DRAINAGE INFORMATION SHEET

PROJECT TITLE: Crossland ZONE ATLAS/DRNG, FILE#: L-16/1023 F
DRB #: 97-533 EPC #: Z-97-126 WORK ORDER #: _____
LEGAL DESCRIPTION: Lot 3A, Cavan Sunport Addition
CITY ADDRESS: 2321 International
ENGINEERING FIRM: Mark Goodwin & Associates CONTACT: John MacKenzie
ADDRESS: P.O. Box 90606 PHONE: 828-2200
OWNER: ESA Management Inc. CONTACT: John Lidbury
ADDRESS: 5495 Beltline Rd, Suite 130, Dallas PHONE: 972-726-8568
ARCHITECT: Alliance Architects CONTACT: Robert Nieporte, Jr.
ADDRESS: 12750 Merit Dr., Suite 550 LBS2, Dallas PHONE: 972-233-0400
SURVEYOR: _____ CONTACT: _____
ADDRESS: _____ PHONE: _____
CONTRACTOR: _____ CONTACT: _____
ADDRESS: _____ PHONE: _____

RE: *CROSSLAND (~~L-16-D23~~). GRADING AND DRAINAGE PLAN FOR SITE DEVELOPMENT PLAN FOR BUILDING PERMIT, BUILDING PERMIT, AND SO #19 PERMIT APPROVALS. ENGINEER'S STAMP DATED 3-10-98.*

RE: *CROSSLAND (L16-D23). GRADING AND DRAINAGE PLAN FOR SITE DEVELOPMENT PLAN FOR BUILDING PERMIT, BUILDING PERMIT, AND FOUNDATION PERMIT. ENGINEER'S STAMP DATED 12-15-97.*

**GRADING AND DRAINAGE PLAN**

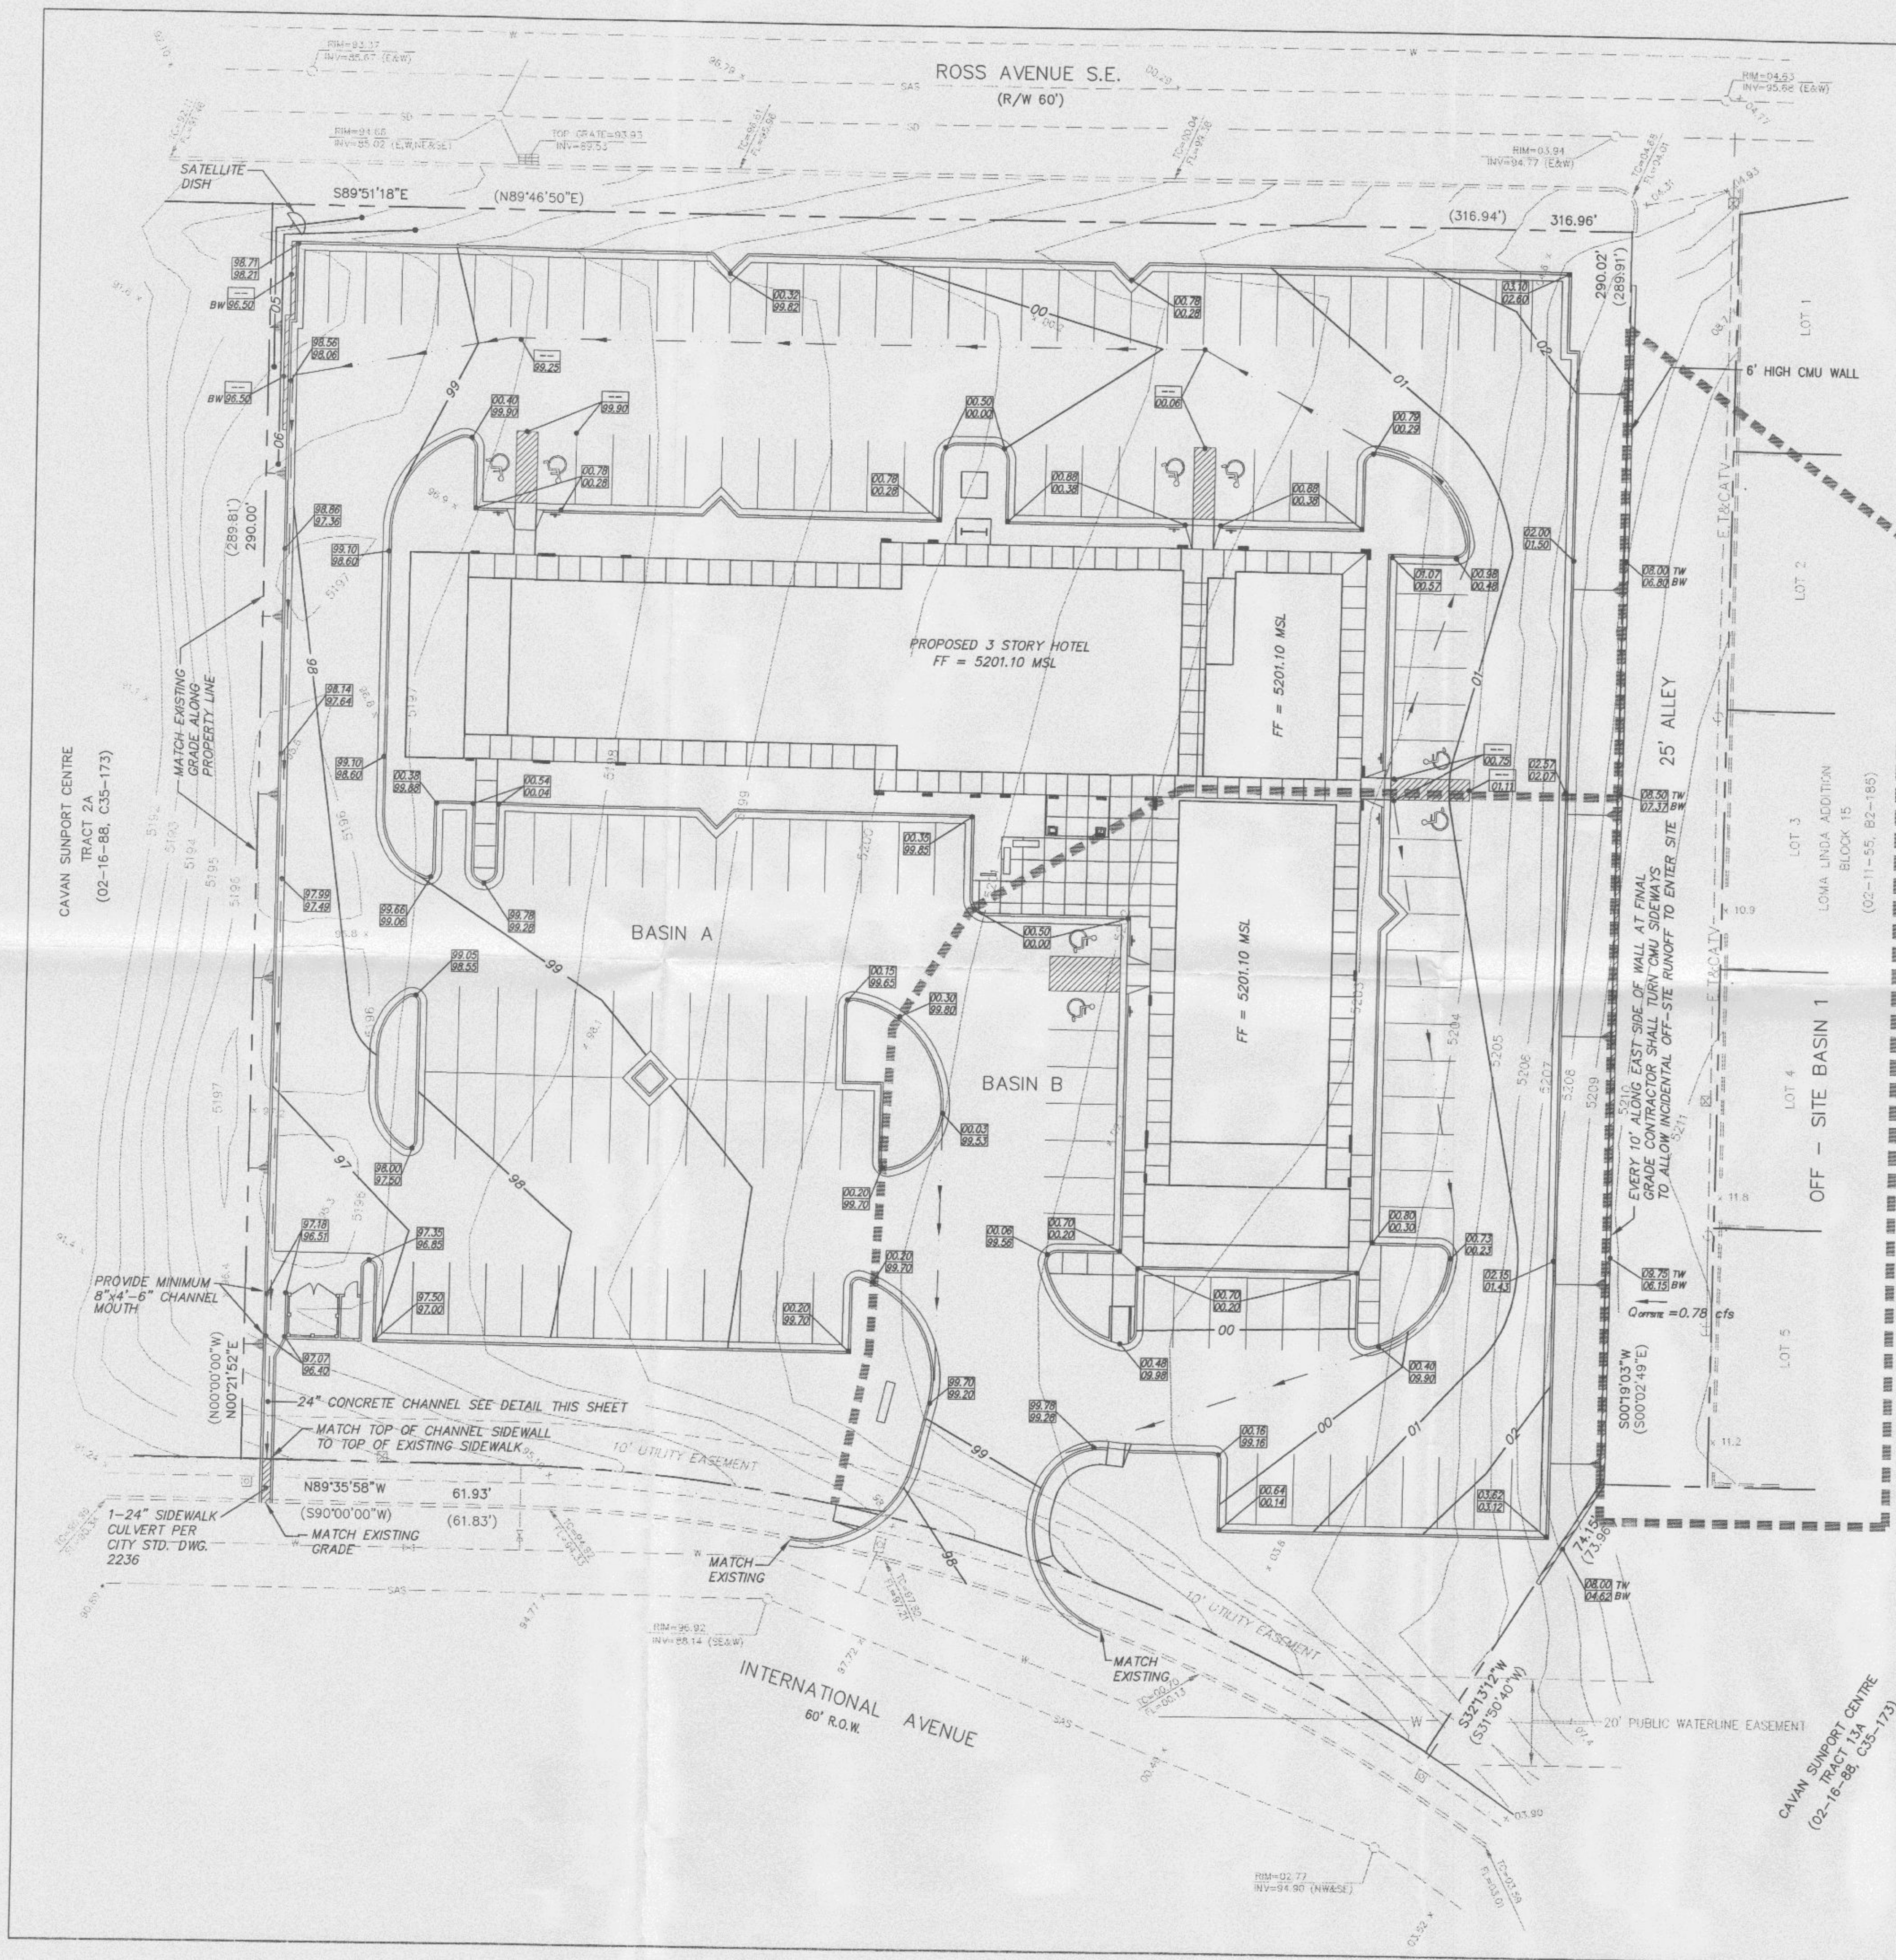
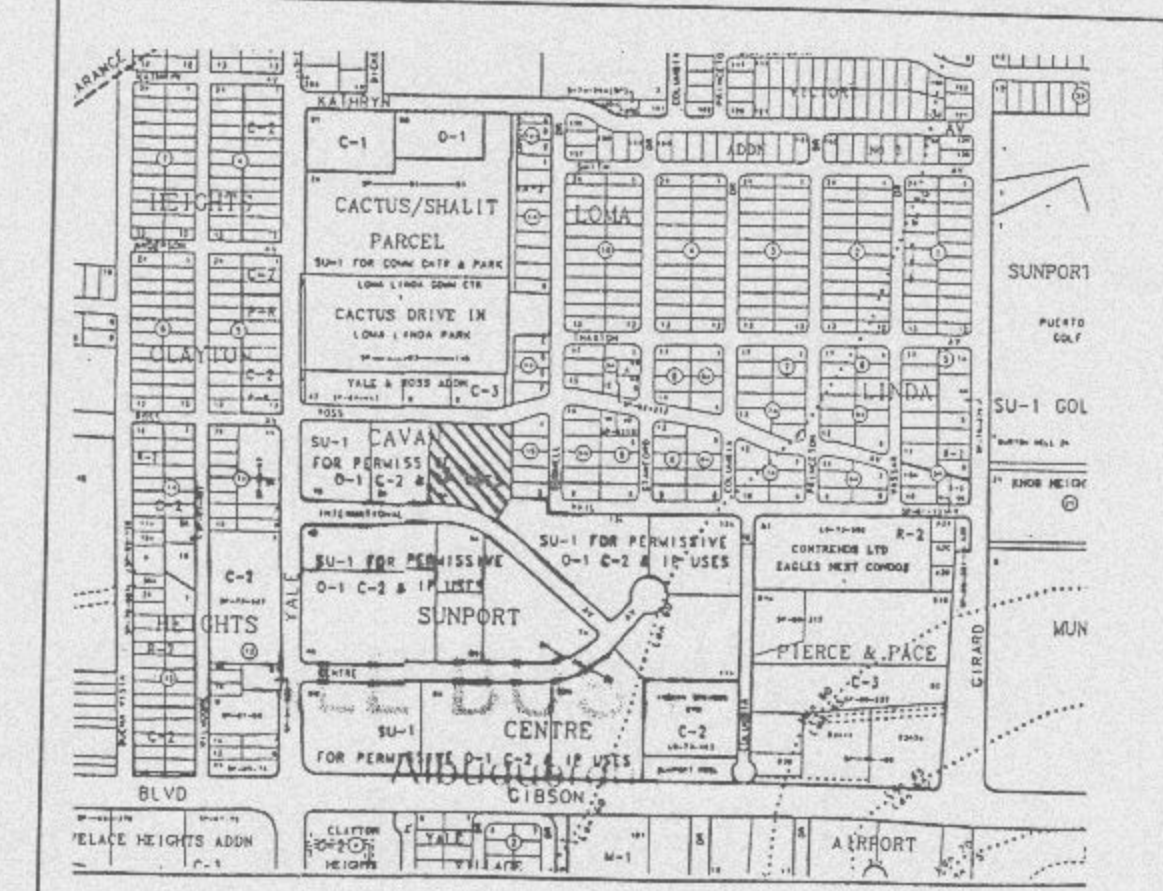
1. Provide finish floor elevation for all three proposed buildings.
2. What is the slope of the berm along the west property line? How will the access easement ever be used?
3. Provide applicable information showing allowable discharge. You may not have free discharge because the master plan you referred to used "old hydrology." Do the land treatment types you propose match those defined in the master plan?
4. Address off-site flow.

1. The finished floor elevation has been added to the third building. *Too steep*
2. The slope of the berm along the west property line is *2.5:1* within the site. It's intended to match up with existing grade. The previously displayed access easement has been eliminated.

4. Minor off-site flow from the east (0.78 cfs, see AHYMO) of this site presently crosses the east property line and impacts this site. The off-site basin comprises an unimproved city-owned alley and back yards of lots just east of the alley. There is a drainage basin boundary running north-south approximately half-way into the residential lots, meaning the fronts of these lots discharge into the street (Cornell) upon which they front. To the block wall along the east property line has been added a note instructing the contractor to allow for these off-site flows to be received by the subject site.
